Planning Application Ref: **AW/267/20/T**

Location: **Wynard, 47 Kingsway, Aldwick, PO21 4DN**

Description of works: **1No. mature sycamore (T1) - Reduce height to 10m and spread 6m. 1No. semi mature sycamore (T4) - Reduce height to 8m and spread to 5m**

47 Kingsway, Craigweil
Private estate. PO21 4DN

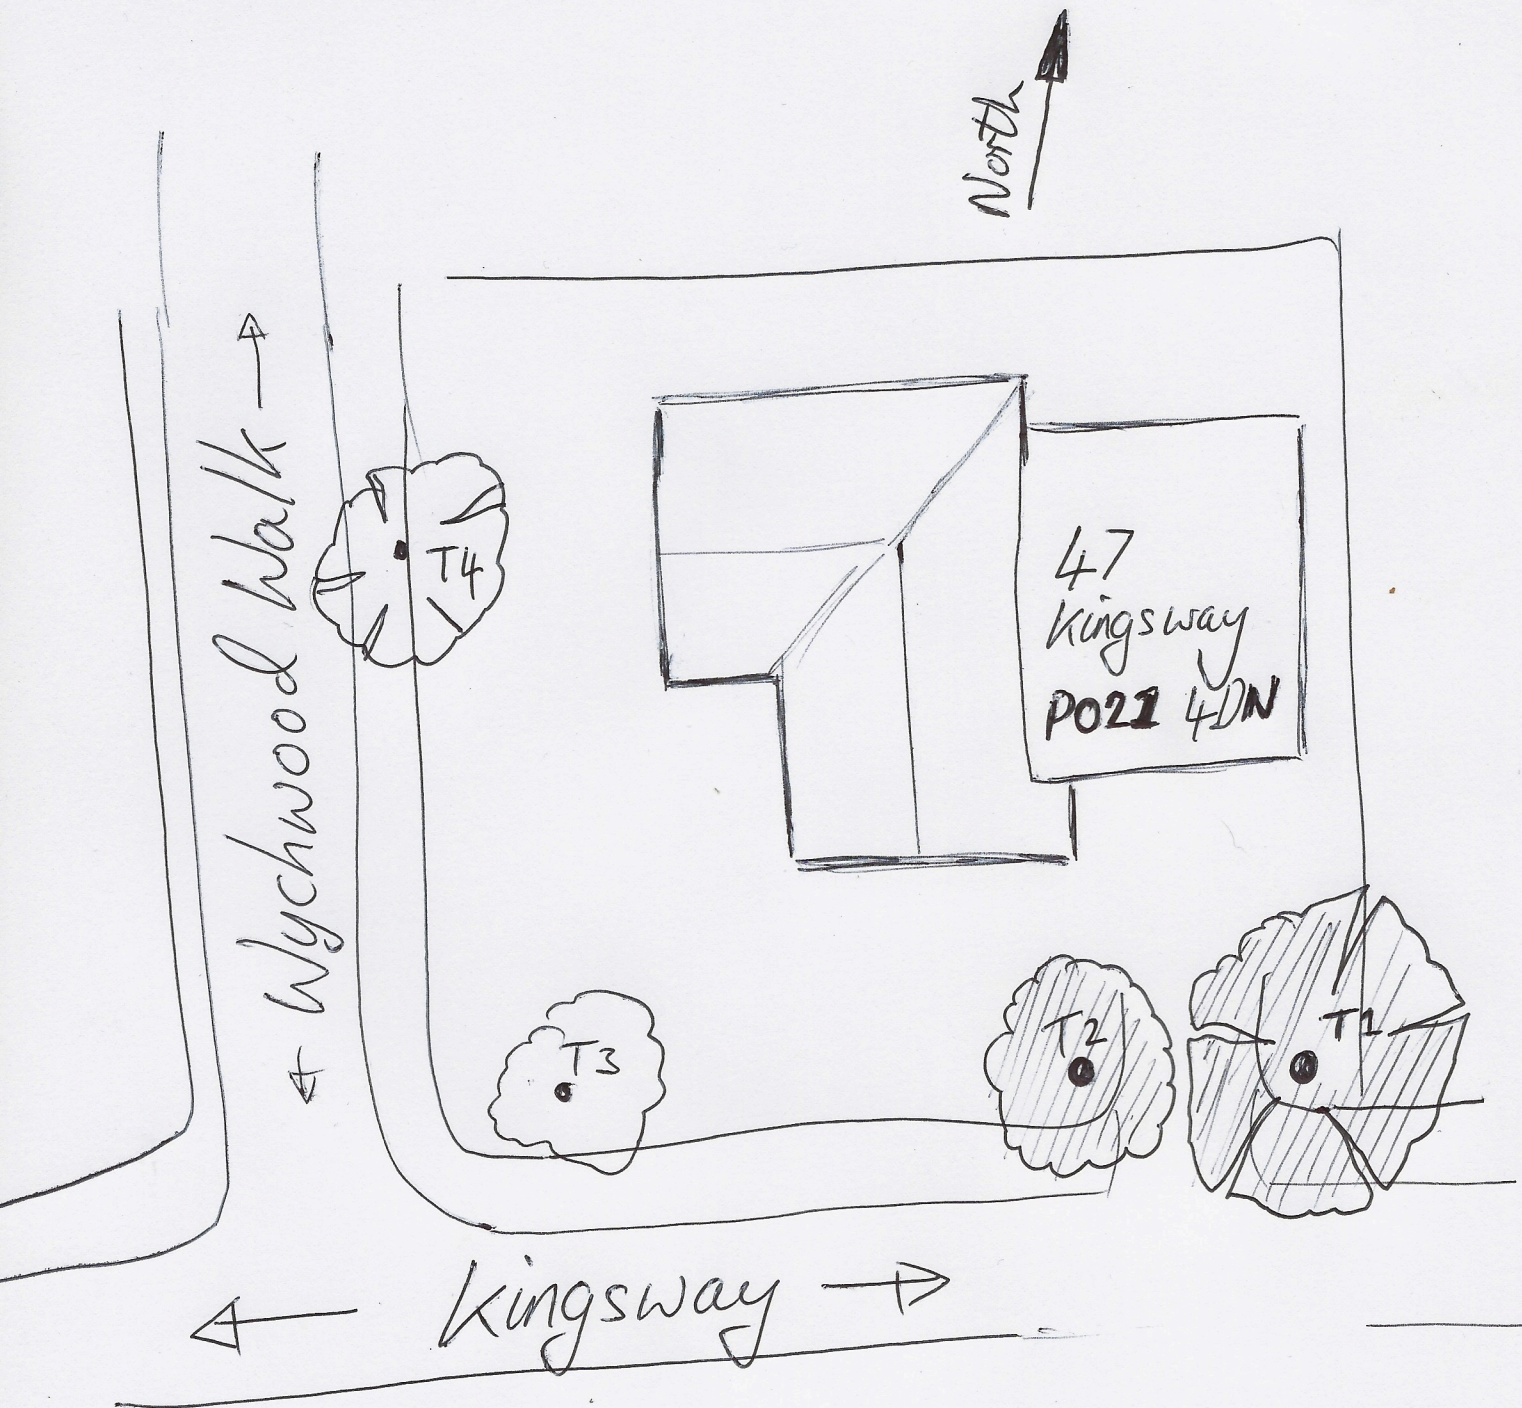
- **T1** is an established tree of apparent good health albeit with a heavily modified crown. It is highly visible from numerous properties and to traffic on the main estate access road.
- Repeat operations such as now being asked for by the applicant will be necessary throughout the remaining lifespan of this tree, to achieve a reasonable degree of structural integrity appropriate for its location.
- **T4** appears to be in fair physiological condition and has moderate form having been previously ‘topped’. It makes only a small contribution to the street scene and character of the wider area.
- Such work as proposed will be necessary throughout the remaining lifespan of this tree, to achieve a reasonable degree of structural integrity appropriate for its location.

- **T1 and T4** - The proposal to reduce their overall height and spread with a view to restricting growth is justified and consistent with previous works approved by the Local Planning Authority.
- While a temporary loss of aesthetic value is inevitable, satisfactory canopy renewal and recovery should occur if the work is undertaken to a high standard and at an appropriate time of year.

- I recommend **CONSENT** for this application, subject to the following condition:

- Part a) Where whole branches are to be removed and final cuts made close to the trunk or branch union they are to be made as shown in Figure 2 of BS3998:2010
- Part b) Where branches are to be shortened back the final cuts are to be made at the correct angle shown in BS3998:2010 and adjacent to a live bud or lateral.
- Part c) Where pollarding or reduction pruning has occurred previously, then the removal of crown material which has developed since the last operation must be done sympathetically and with respect to established ‘knuckles’ so as not to extend beyond the point of origin.
